Subject: RE: Planning Consultation on: Y/150/21/HH

Engineers Comments Regarding Surface Water Drainage

Application No: Y/150/21/HH

Description of Works: Detached single storey home office/garden building in rear garden.

Garden Layout

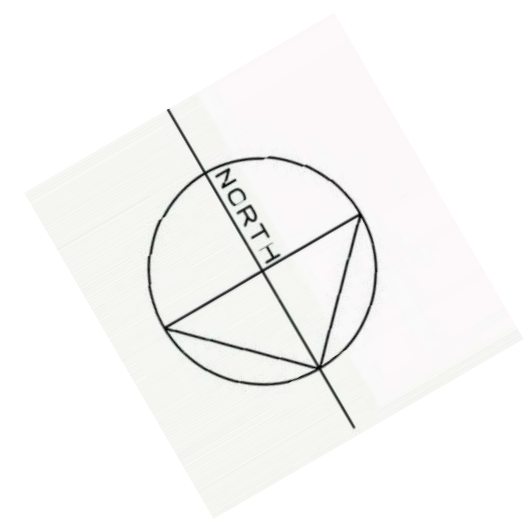
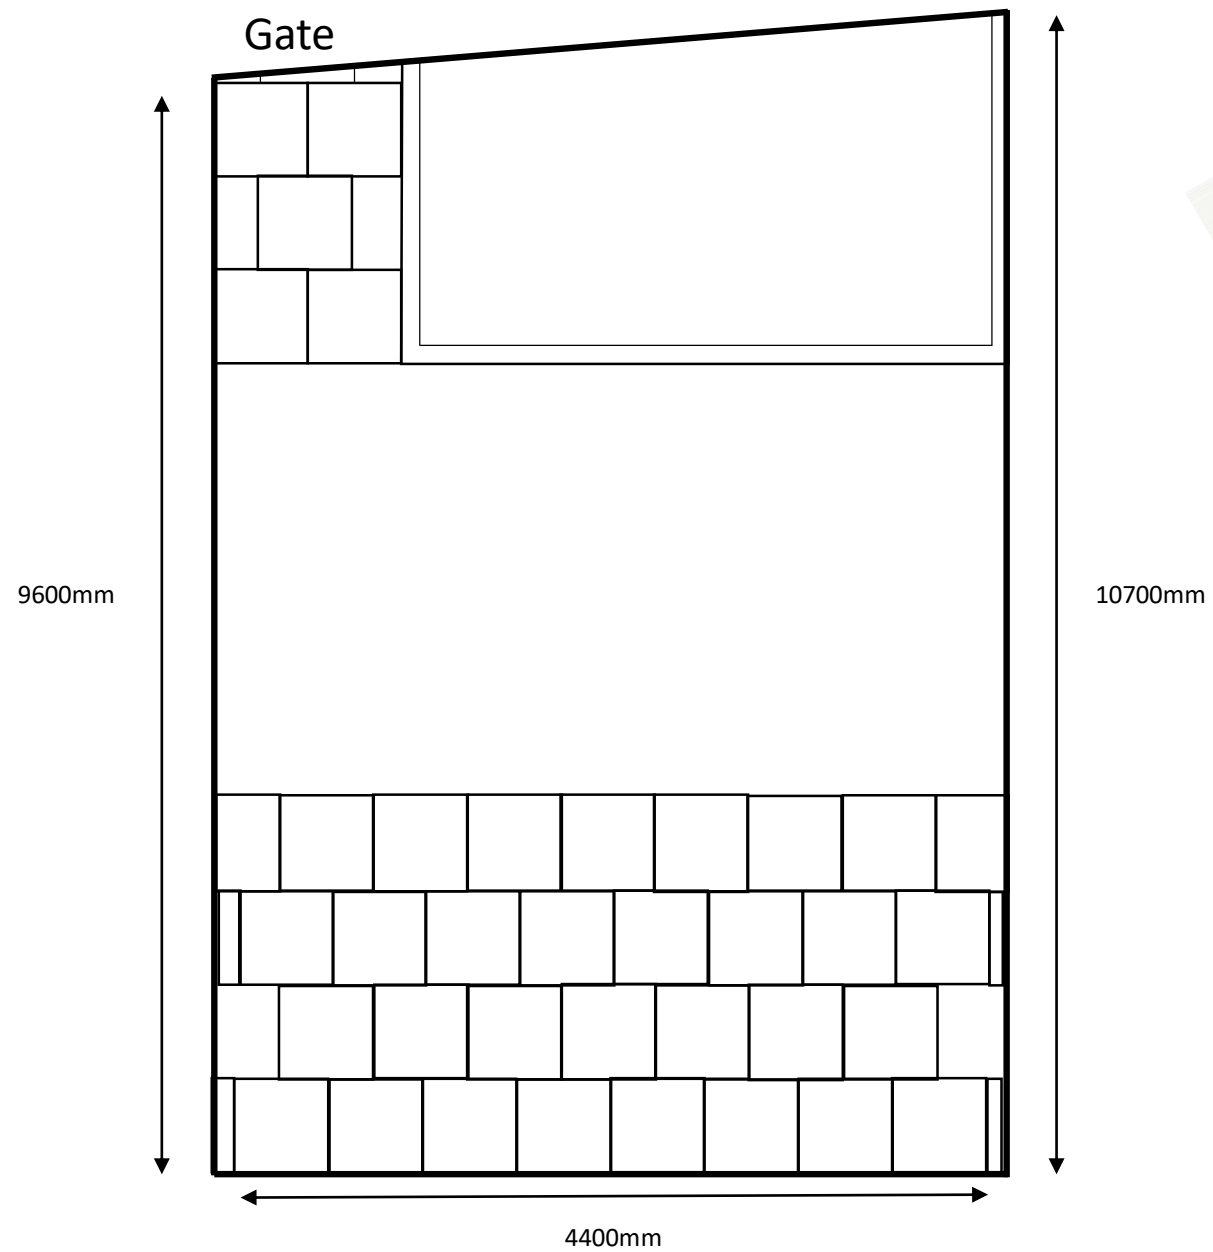
The application site is within a relatively new build estate for which a robust surface water drainage strategy was approved by the LPA under application reference Y/21/18/DOC. Drawing 101 Rev P5 shows the general drainage arrangement for the site. This illustrates a trench soakaway which runs through the garden of the application site (plot 6) between plots 5 and 8.

My expectation is that the applicant will need to show that they can and will connect the surface water drainage from the proposed outbuilding to the existing soakaway, they will need to check the levels of the soakaway and show that it has been constructed as drawn. The construction of the proposed outbuilding must not damage or alter the existing drainage arrangements for the site. I also request this condition to ensure that no connection of surface water is made to the foul sewer in the Lidsey Treatment Catchment.

"Development shall not commence, other than works of site survey and investigation, until full details of the proposed surface water drainage scheme have been submitted to and approved in writing by the Local Planning Authority. The design should follow the hierarchy of preference for different types of surface water drainage disposal systems as set out in Approved Document H of the Building Regulations, and the recommendations of the SuDS Manual produced by CIRIA. No building / No part of the extended building shall be occupied until the complete surface water drainage system serving the property has been implemented in accordance with the agreed details and the details so agreed shall be maintained in good working order in perpetuity."
